PLANNING CONSULTATION RESPONSE

Application No	2026/0566
Proposal	2026 0566 Single Storey Rear Extn The Hayloft Swithen Farm Huddersfield Road Haigh
Address	Swithen Farm Huddersfield Road Haigh
Date of Consultation Reply	280726
Consultee	Tony Wiles Senior Conservation Officer

Project	Rear Extensions & Int. Alts	
Client	Mr Paul Bates	
Title	Elevations as Proposed	
Address	'The Hayloft', Swithen Farm, Huddersfield Road, Haigh, Barnsley. S75 4DG	
Drawn By	GGG	
Scale	1:100 @ A3	Date Jun 26
Drawing No	519-04	Rev

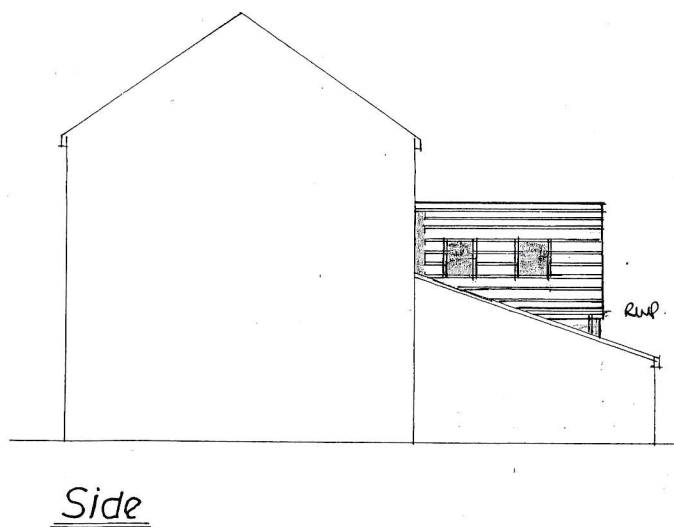
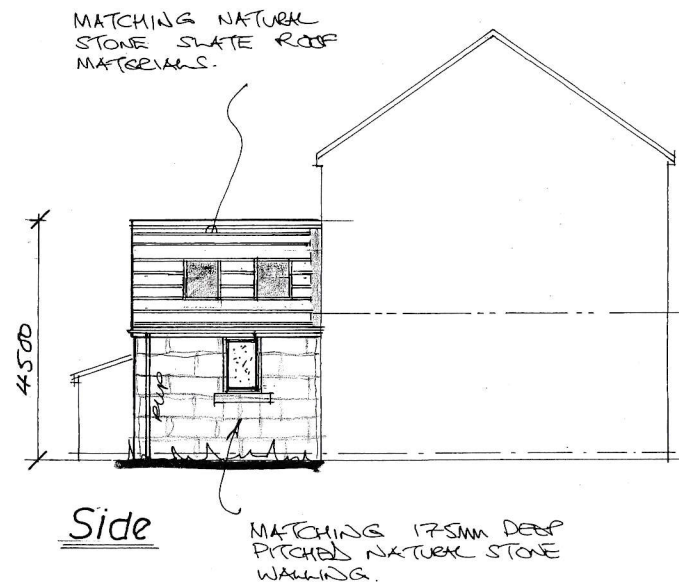
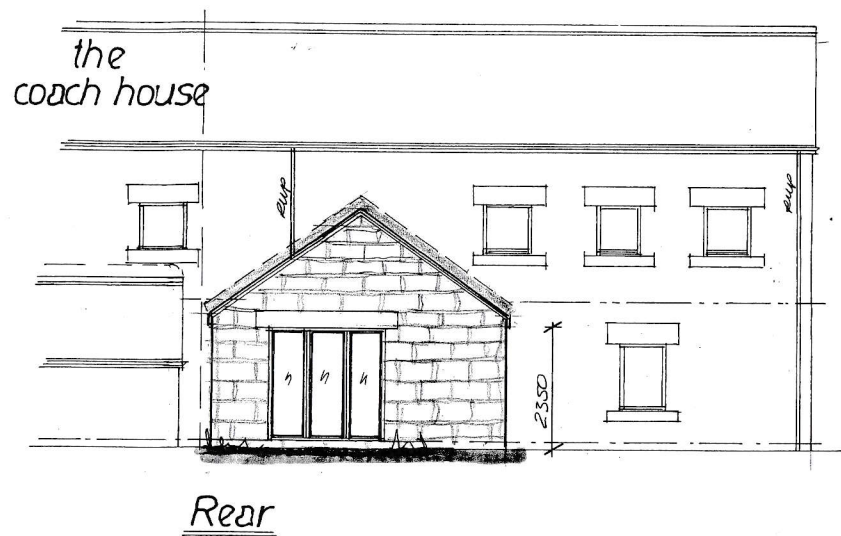
that listed building consent should accompany the planning application for the current proposal. This is mainly due to the close proximity of the barn to Swithen House, the clear functional and historic relationship between the buildings, and the earlier consent precedent. In terms of the host dwelling, it is clearly identifiable as a converted barn and, outwardly, it retains much of its vernacular character and simple historic plan form. The use of traditional detailing, construction methods and materials has helped preserve its agricultural character. It therefore continues to make a positive contribution to the setting and significance of Swithen House. I note that the adjacent property has already been extended with a single-pitch roof form projecting eastwards into the rear garden. This arrangement is not in accordance with the Barn Conversions SPD, which generally advises that extensions should be attached to the shorter gabled elevations in order to preserve the historic plan form. However, I accept that this existing extension establishes a local precedent and has been carried out with a reasonable degree of sympathy. It also reflects similar lean-to additions at The Granary and The Dovecote. On that basis, I consider that an extension to The Hayloft may be acceptable in principle. However, I object to the gabled form of the current proposal. The submitted roof form would appear at odds with the established character of the neighbouring extensions and would not sit comfortably alongside the immediately adjacent extension to The Coach House. To better preserve the simple agricultural character of the former barn range and safeguard the setting of Swithen House, the extension should instead adopt a lean-to, single-pitched roof form. This better reflects roofs and extensions of adjacent properties. The most appropriate material for the roof would be a natural sandstone slate roof covering, with conservation rooflights. Walls in coursed natural sandstone, with course heights, face dressing and pointing to match the existing building are the ideal.

Beyond the form of the proposal, I do not object in principle. However, amended plans that better reflect the host building and adjacent extensions would allow me to support this application and agree it is in accordance with S.16(2), 66(1) of the Act, Local Plan policies HE1 and HE3, and NPPF 212.
